RE: Westwood Village - CCIC Project

RE: Westwood Village (J-10-D8)

REFERENCE: WESTWOOD VILLAGE (J-10-D8)

DRAINAGE REPORT & GRADING PLAN  
for  
Westwood Village,  
HUD Housing Project  
on 68th Street NW  
Albuquerque, NM October 1981

GRADING PLAN

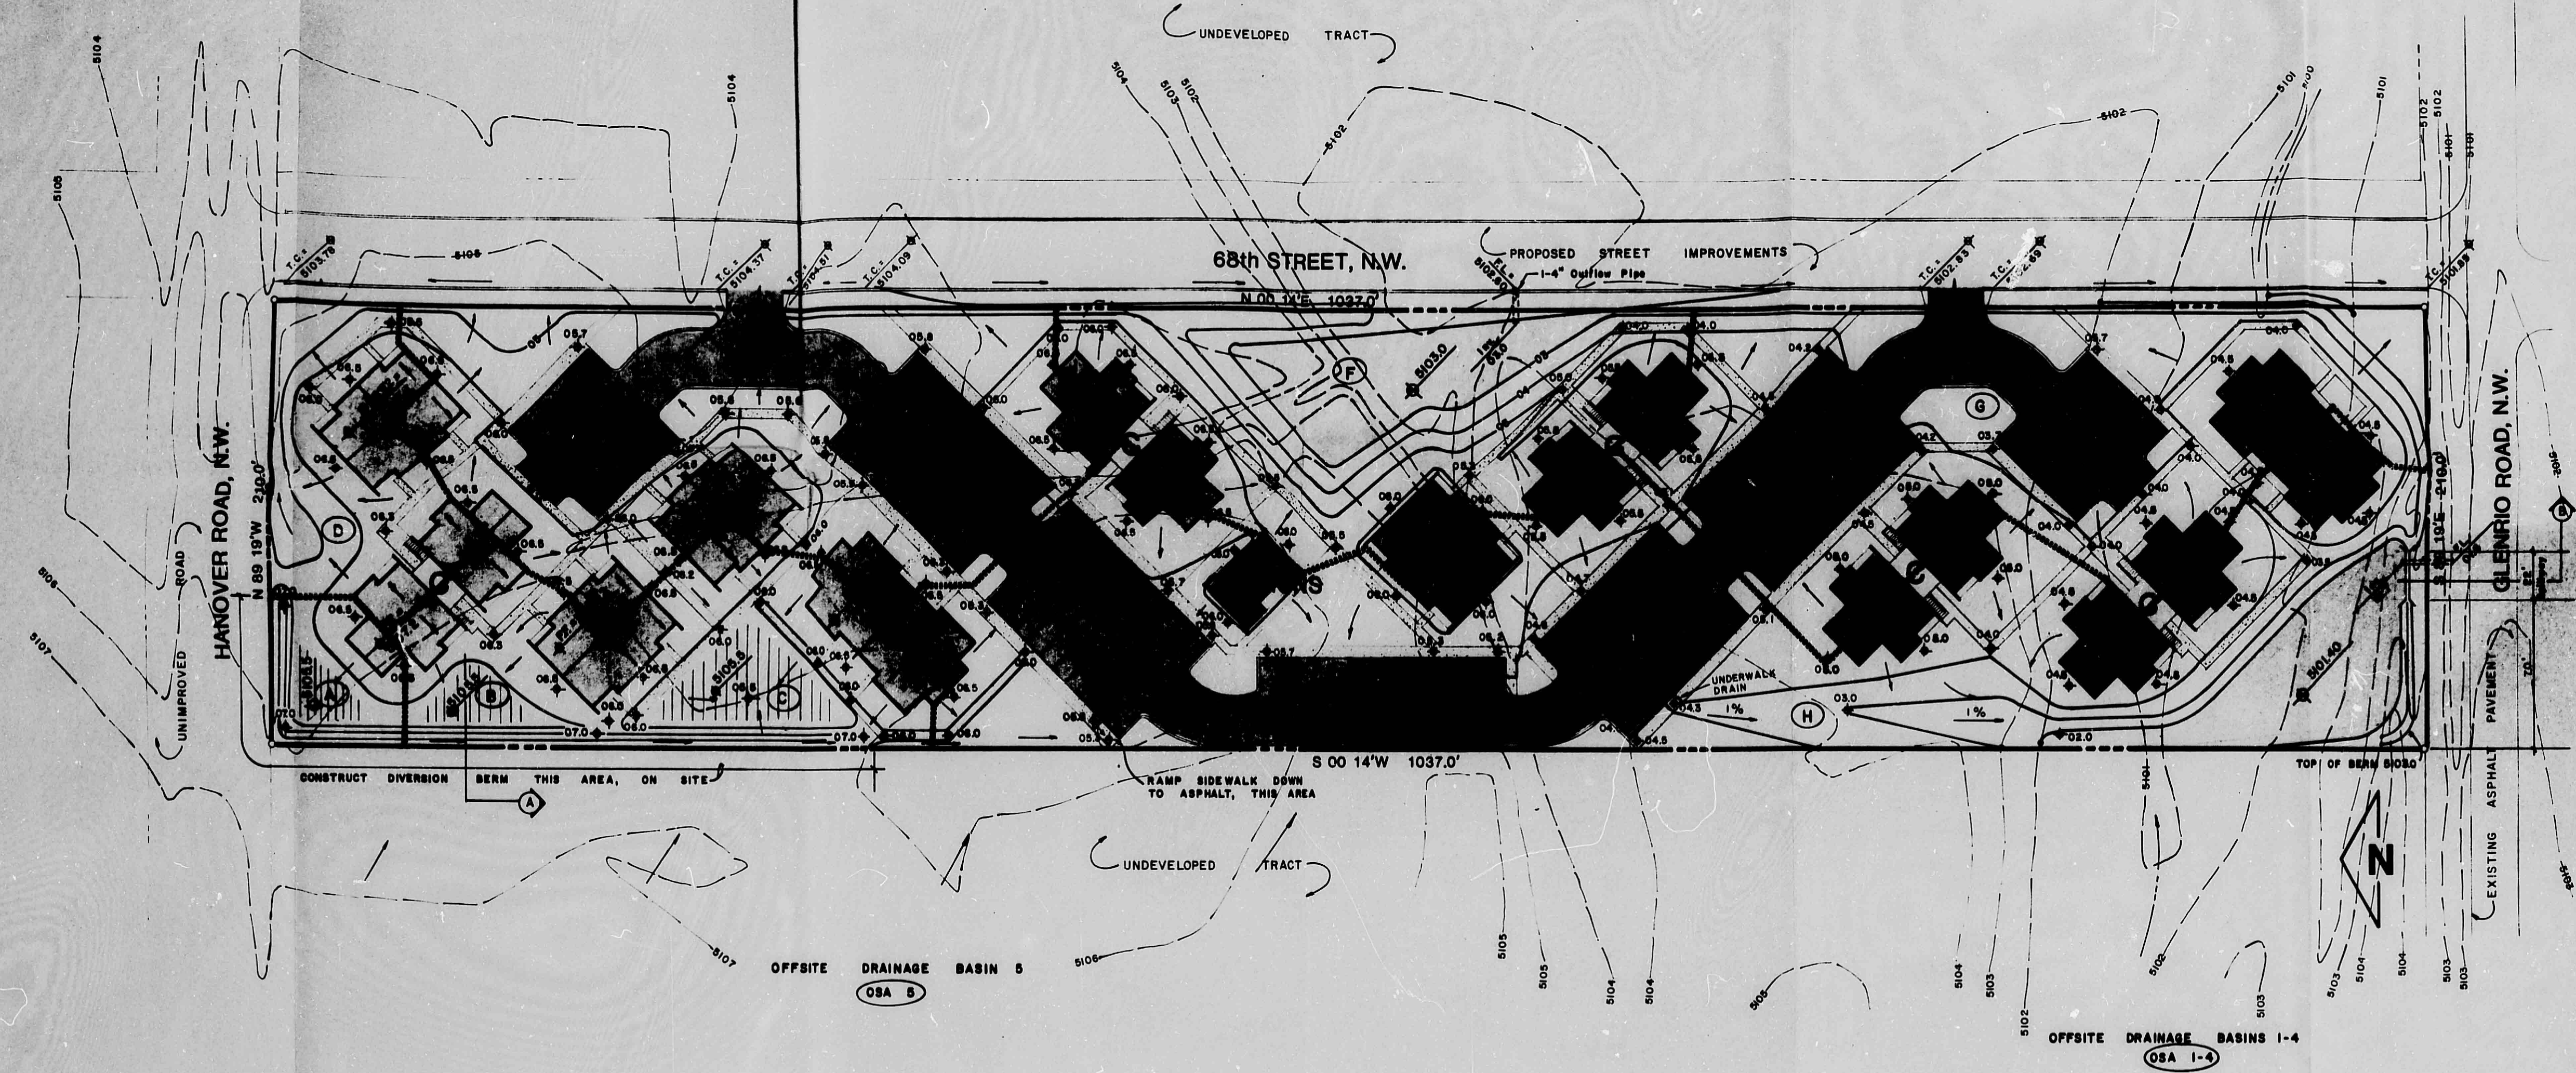
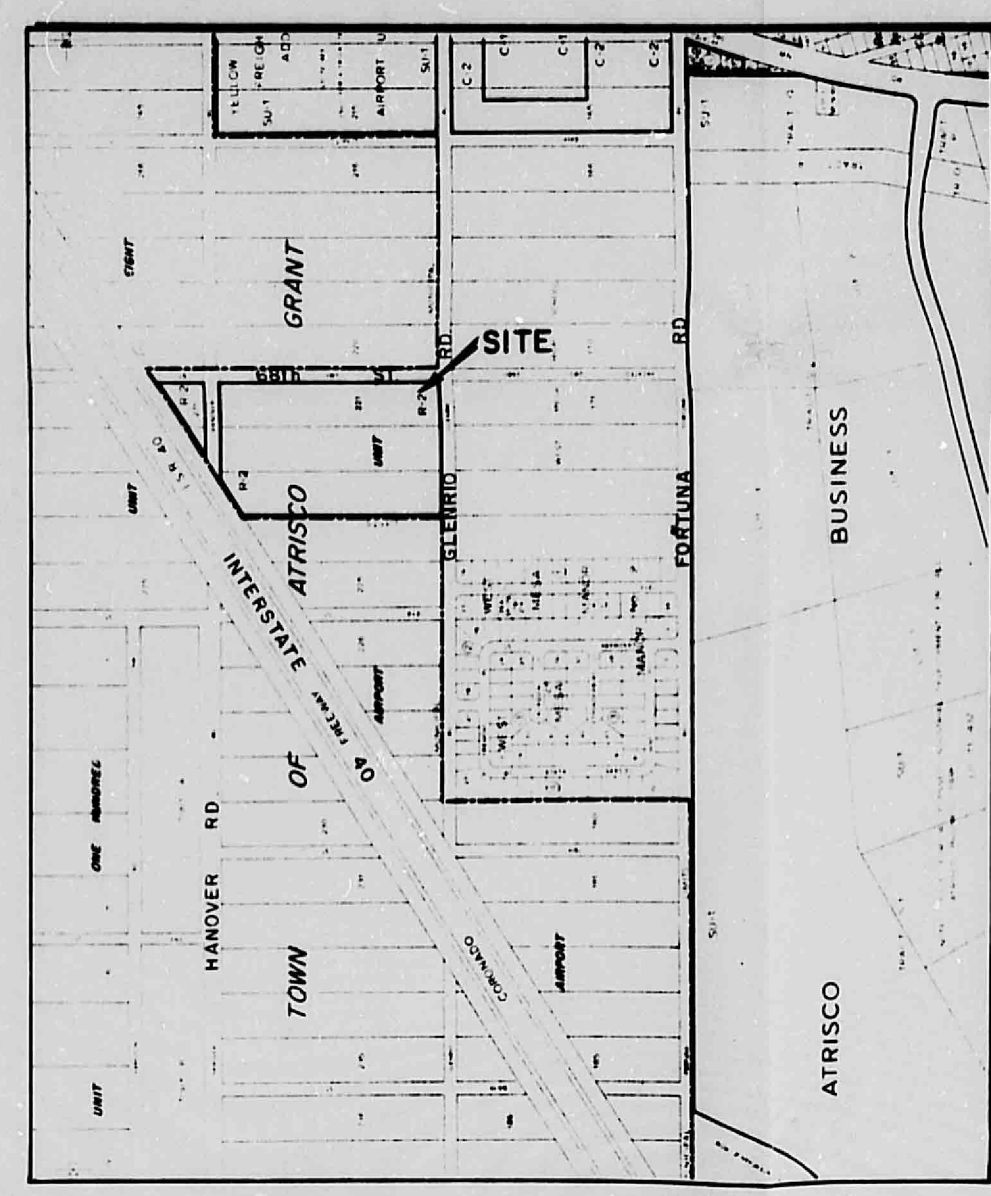
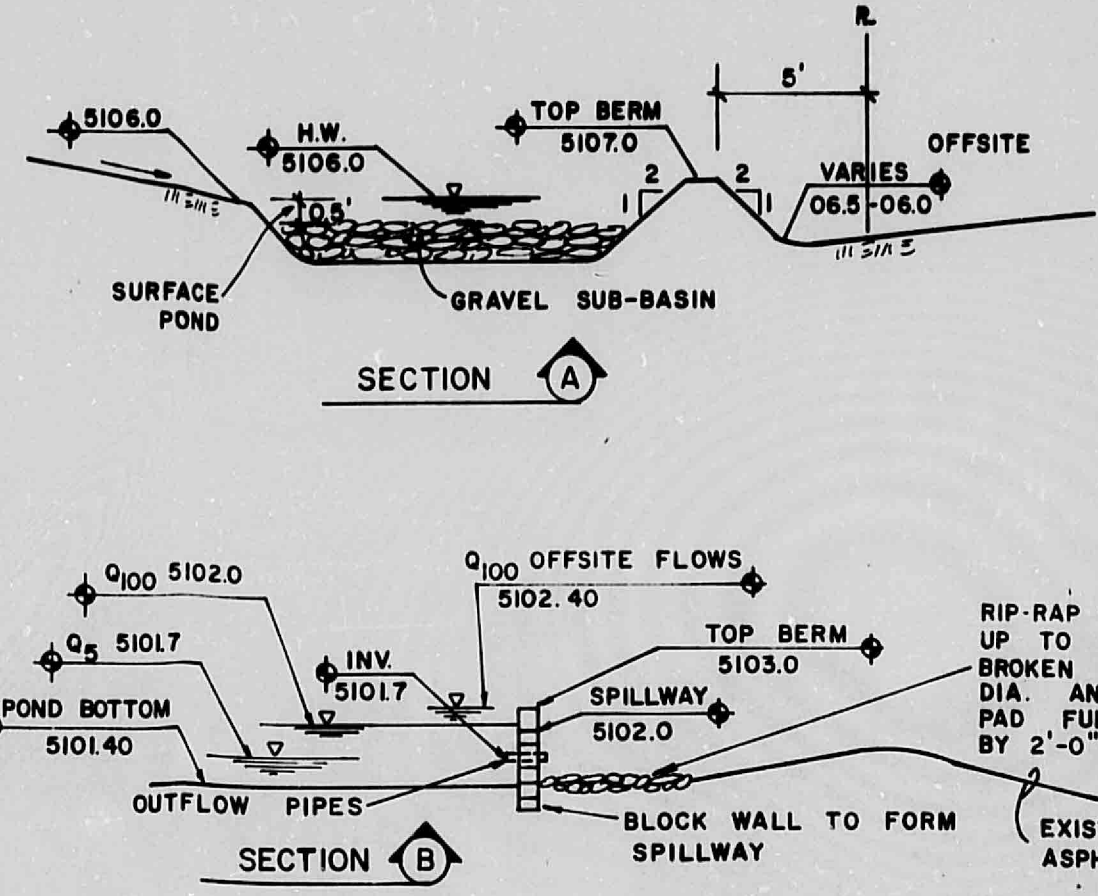
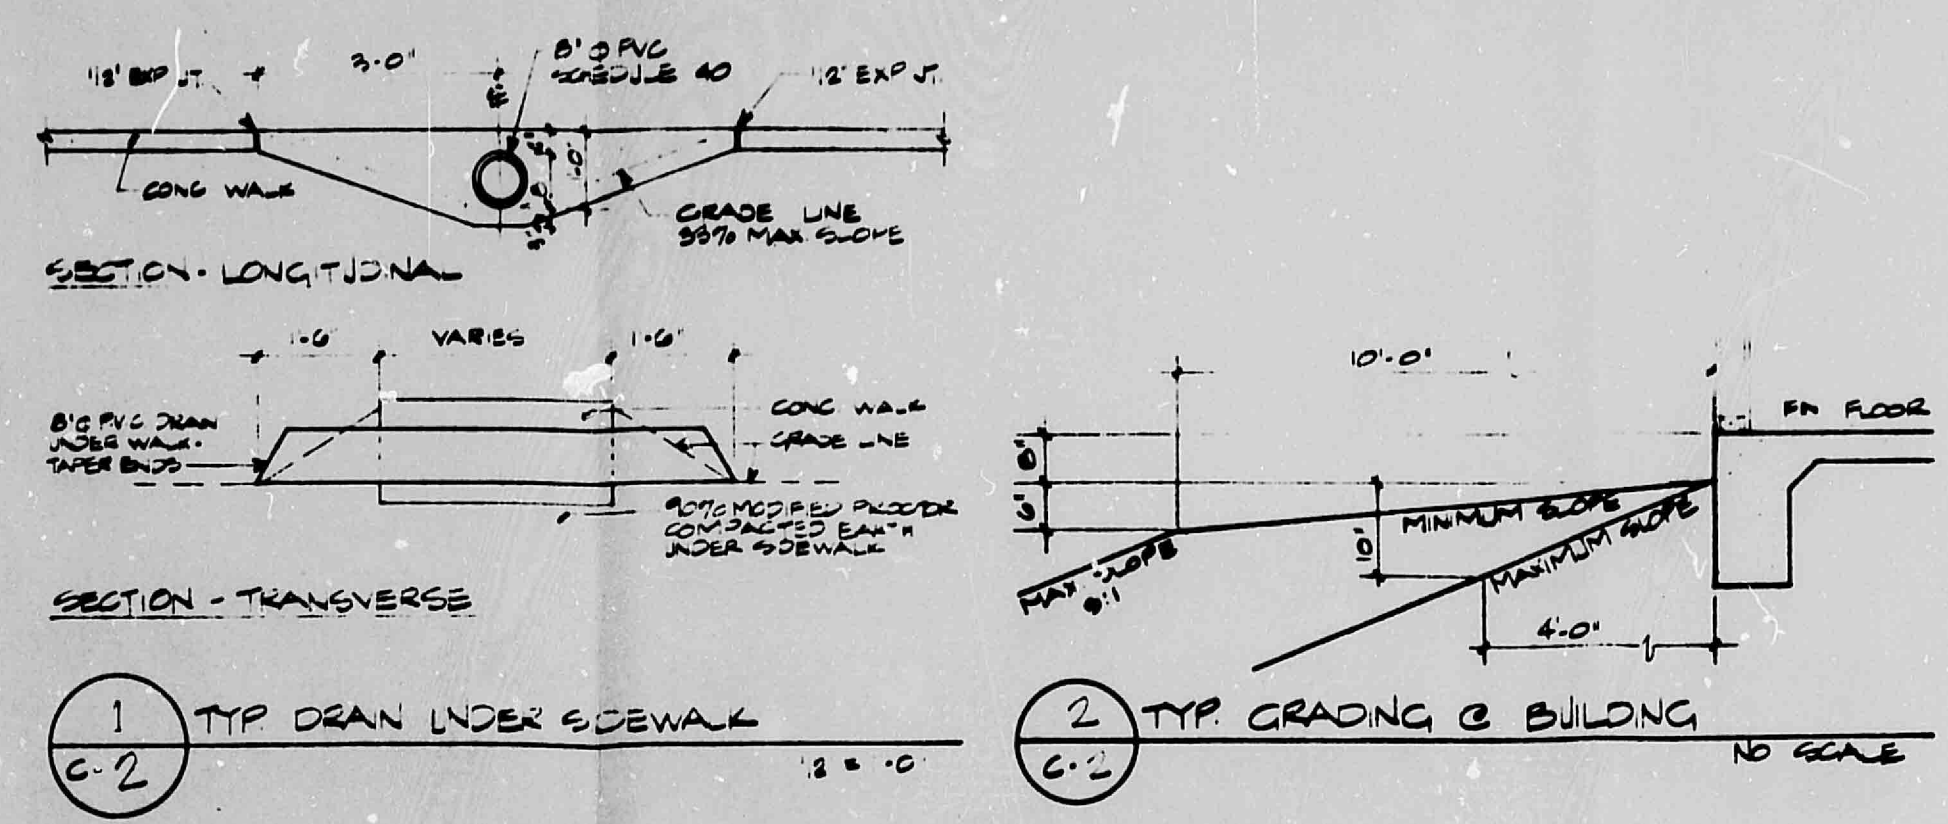
Item 11A: We added further clarification of the interceptor swale, with drainage capacities noted on the plan, page C-3.

Item 21M: Dimensions have been added to cross-sections and plan.
